From: Sarah Burrow <Sarah.Burrow@arun.gov.uk>
Sent: 06 January 2020 16:08
To: Simon Davis <Simon.Davis@arun.gov.uk>
Cc: Paul Cann <Paul.Cann@arun.gov.uk>
Subject: RE: Planning Consultation on: BE/109/19/OUT

Engineers Comments Regarding Surface Water Drainage Design

APPLICATION NO: BE/109/19/OUT

Site Address: Land east of Shripney Road & south of Haddan House Shripney
Road Bersted PO22 9NW

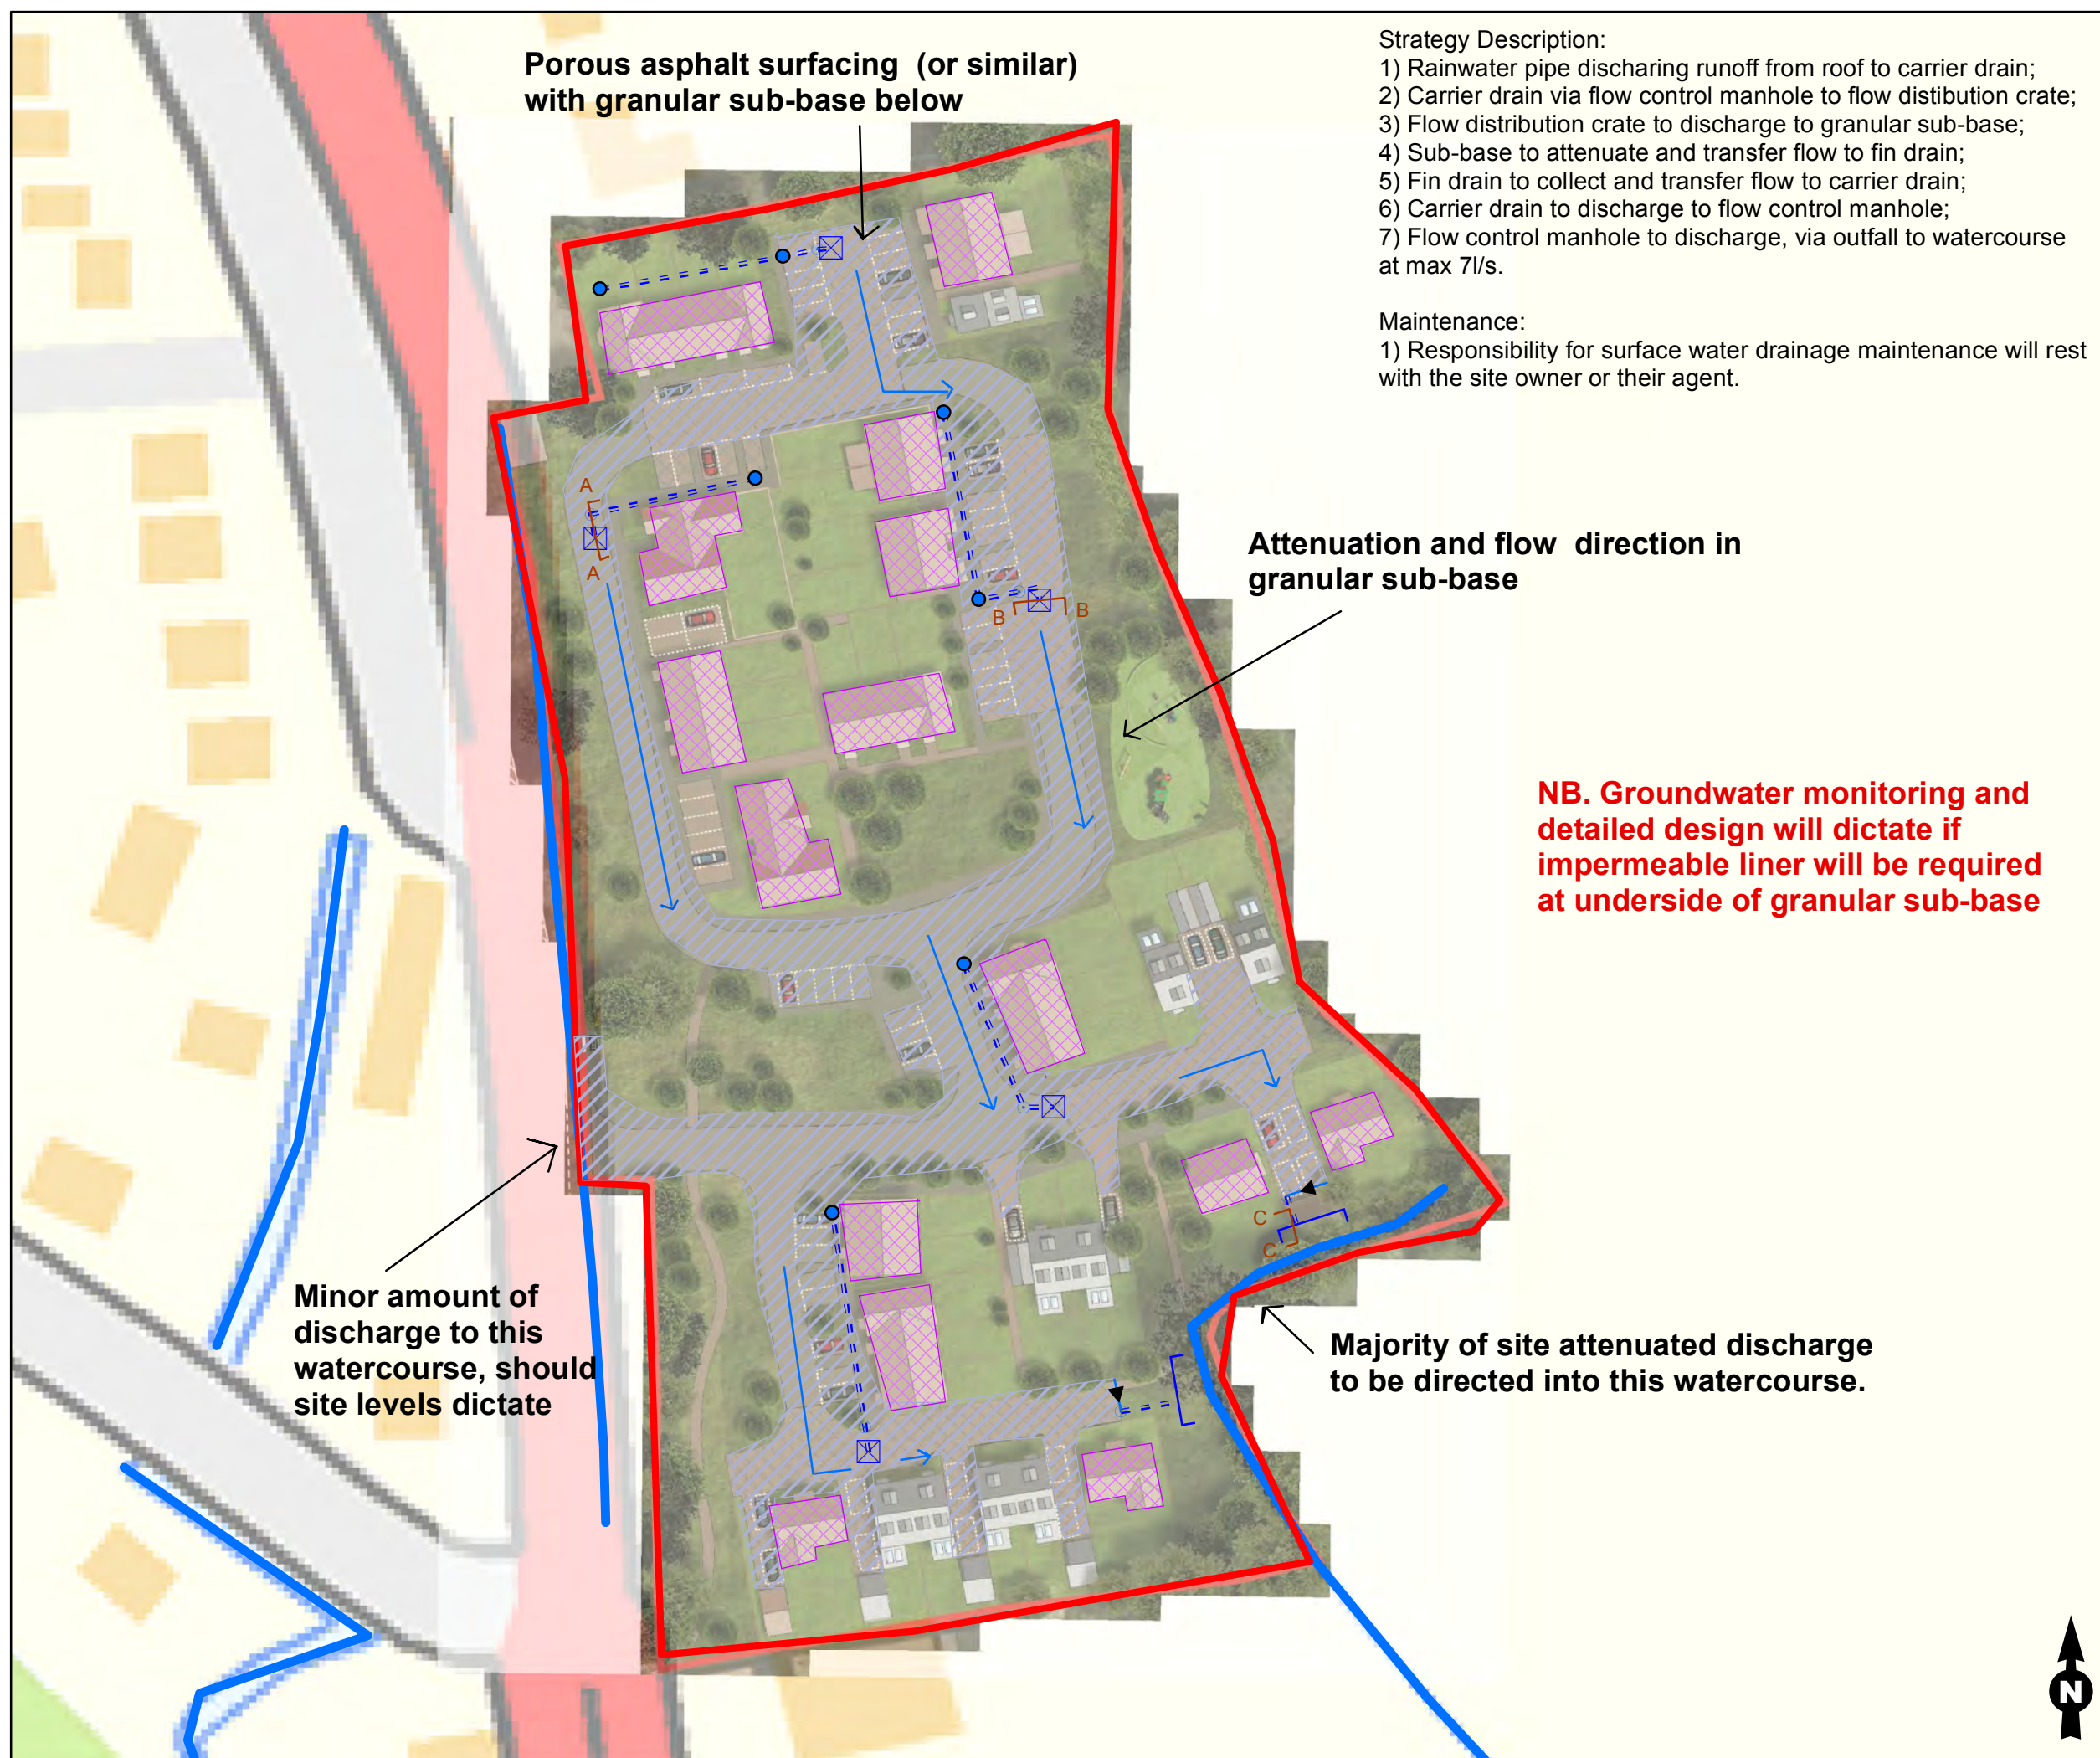
The surface water drainage strategy is proposing to use permeable paving (infiltrating or lined depending on groundwater and infiltration test results) and an underground attenuation tank with restricted discharge to two boundary watercourses. The strategy discounts the use of any open features (balancing ponds, swales and detention basins) on the basis of 'limited space available space [sic] within the proposed development site.' Surface water drainage must be considered at the earliest opportunity and form part of the layout development process, therefore having limited space is not a reasonable excuse. Leaving drainage design until after a layout has been agreed will likely unduly prejudice drainage design and not allow for the hierarchy for sustainable drainage to be followed.

Therefore it is asked that the applicant reconsider the layout of the proposed development in order to incorporate open surface water drainage features to minimise storage in underground attenuation tanks. It is believed that this is possible without changing the location of buildings. It may also be possible to extend the permeable paving to provide a blanket infiltration solution.

Furthermore the applicant proposes discharging some of the surface water from the site to the watercourse on the western boundary. There are known capacity issues at this watercourse and it may be necessary for the applicant to carry out remedial works to the watercourse and downstream culvert in order to gain permission to discharge to it.
